From: Thomas Callaway
Sent: 30 October 2014 16:38
To: Planning.Responses
Subject: RE: Planning Consultation on: AL/72/14/HH

APPLICATION NO: AL/72/14/HH

Site Address: Caigers Cottage Westergate Street Aldingbourne PO20 3SQ

Description of Works: Roof extension with new staircase over single storey accomodation & single storey extension on west elevation.

PROPOSED GROUND FLOOR 1:100@A1

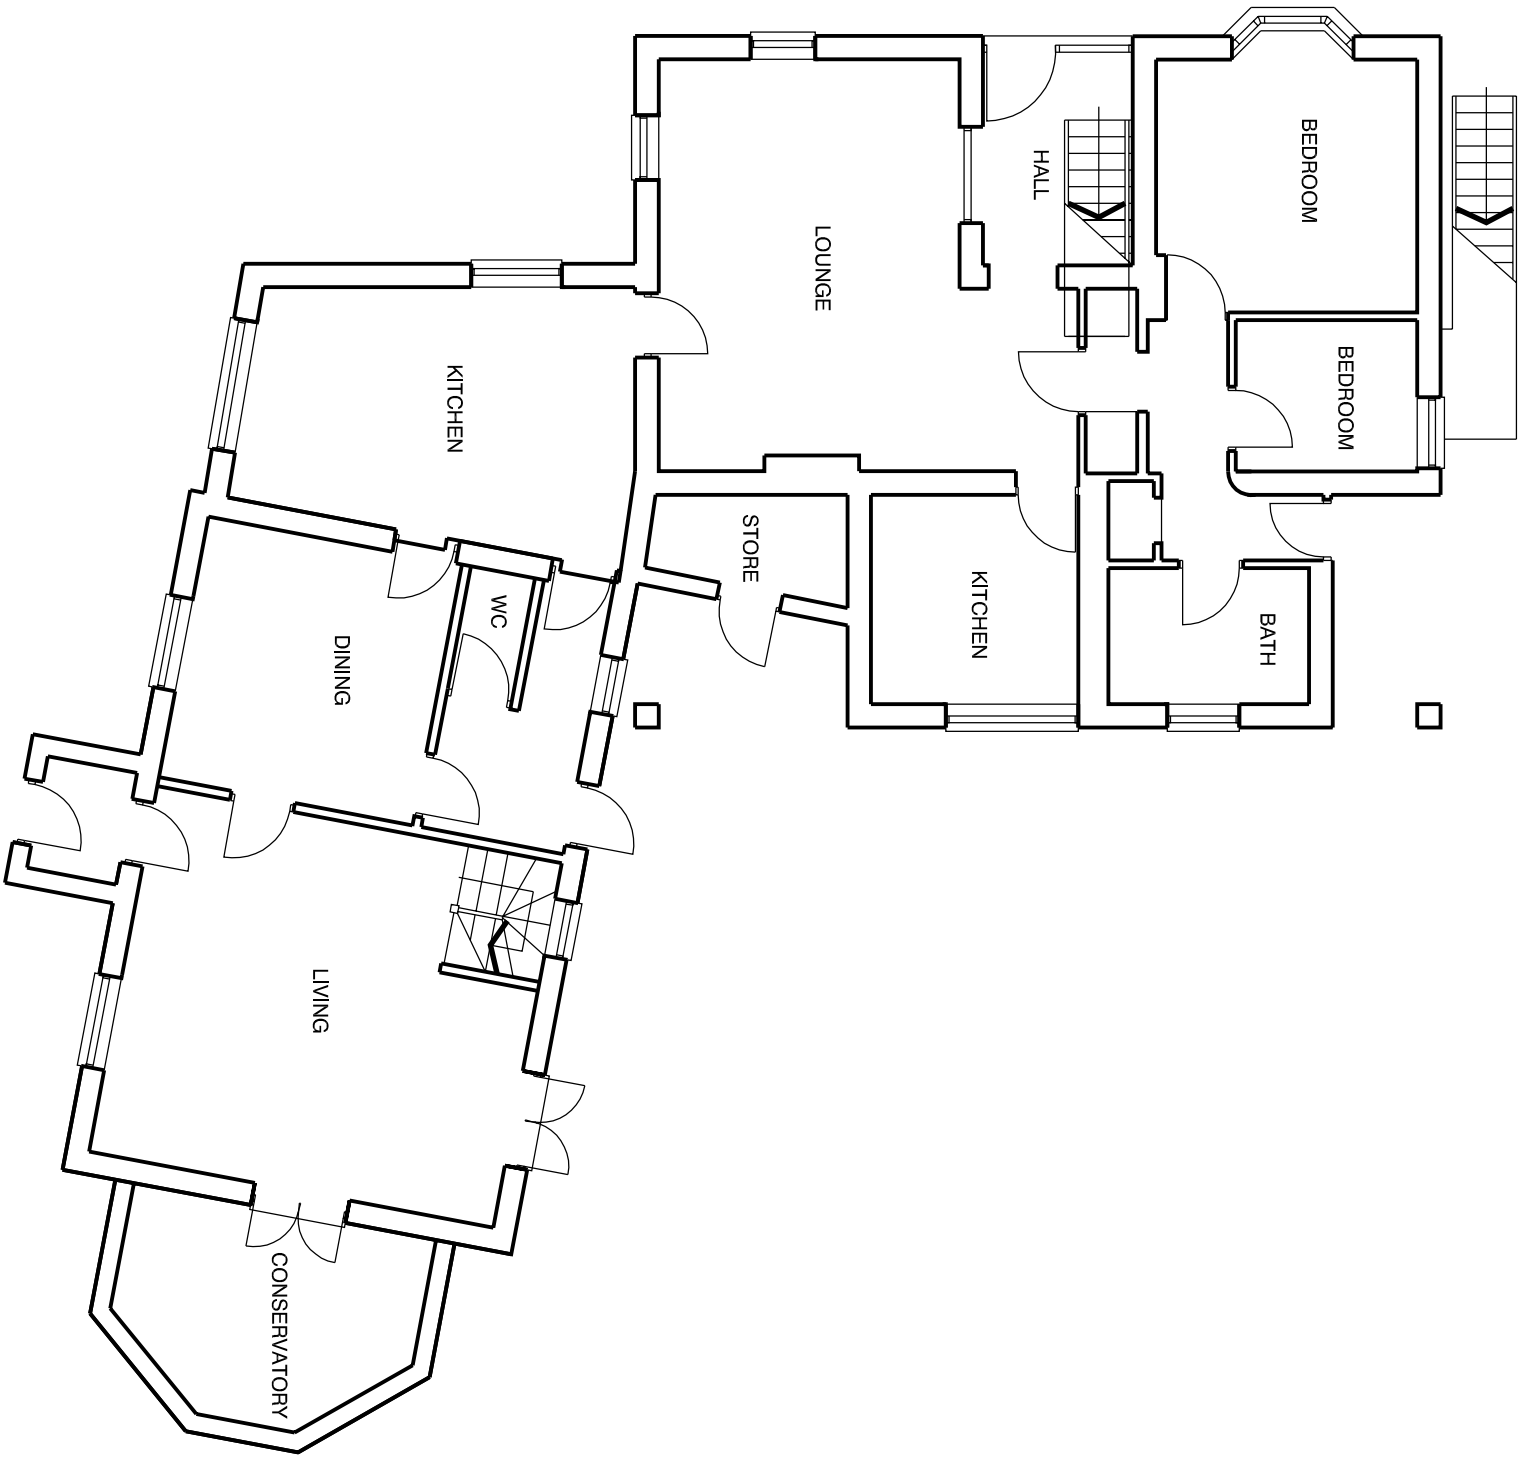
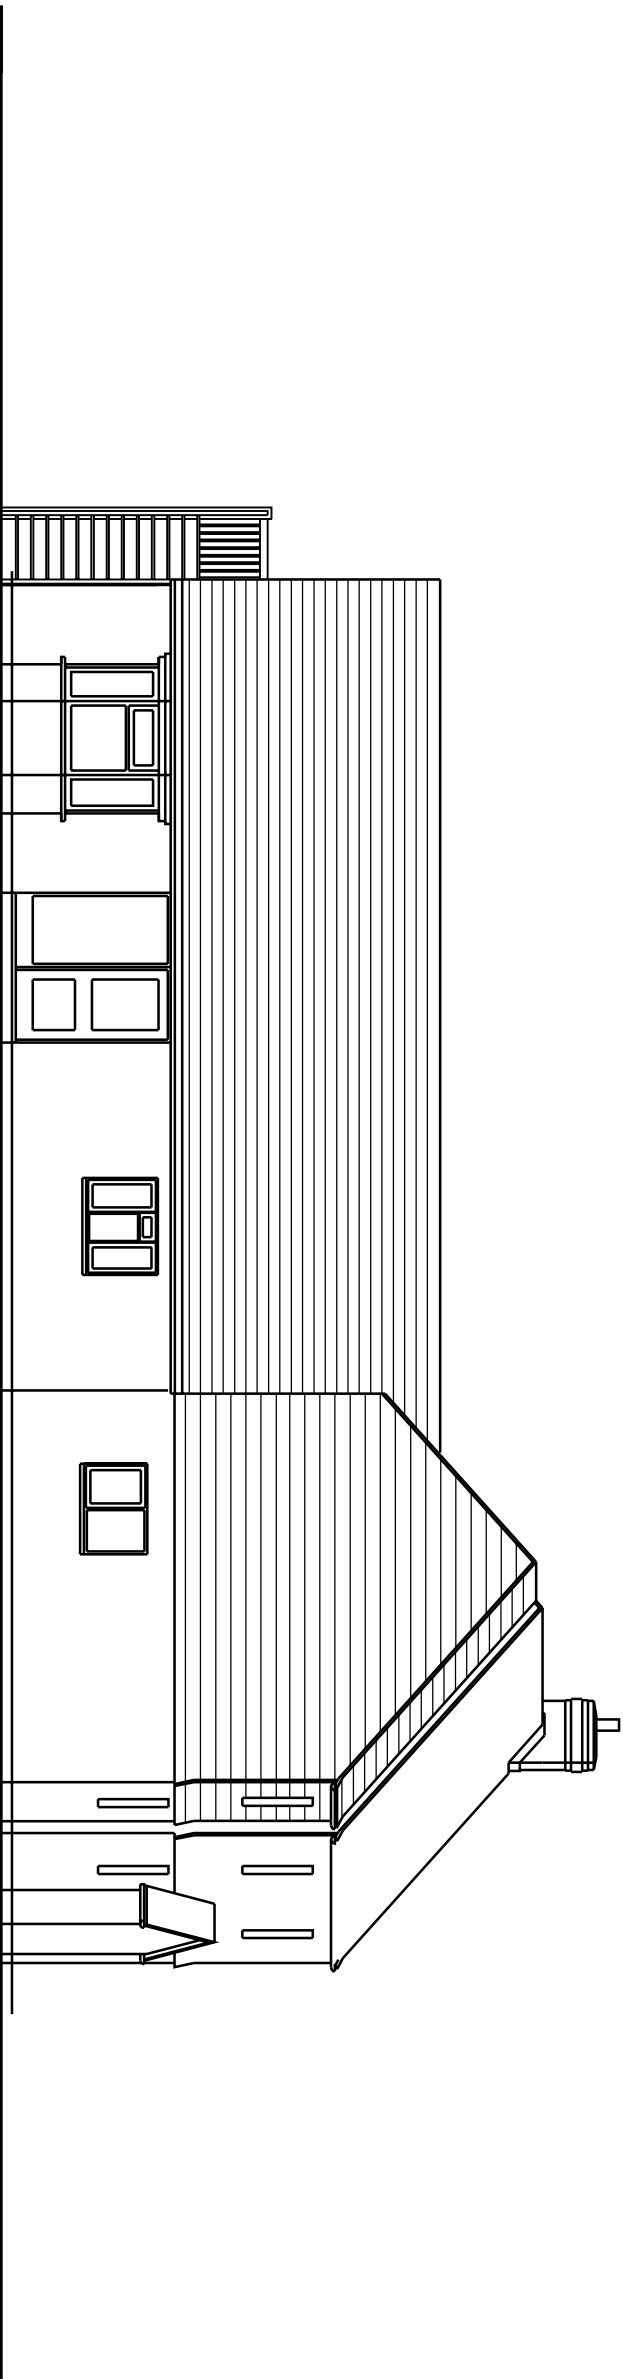
Surface water drainage of the extension should be considered.

The small area of the extension means that it is likely that one or two geocellular soakaway crates may provide sufficient storage for the surface water generated by a 1 in 100 year storm event plus 30%.

The groundwater level should be checked to ensure that shallow soakage is suitable – the crates should be positioned above the peak groundwater level. Soakage test to BRE 365 or similar should be used to confirm suitable infiltration rate.

ENG2A should be applied guidance attached
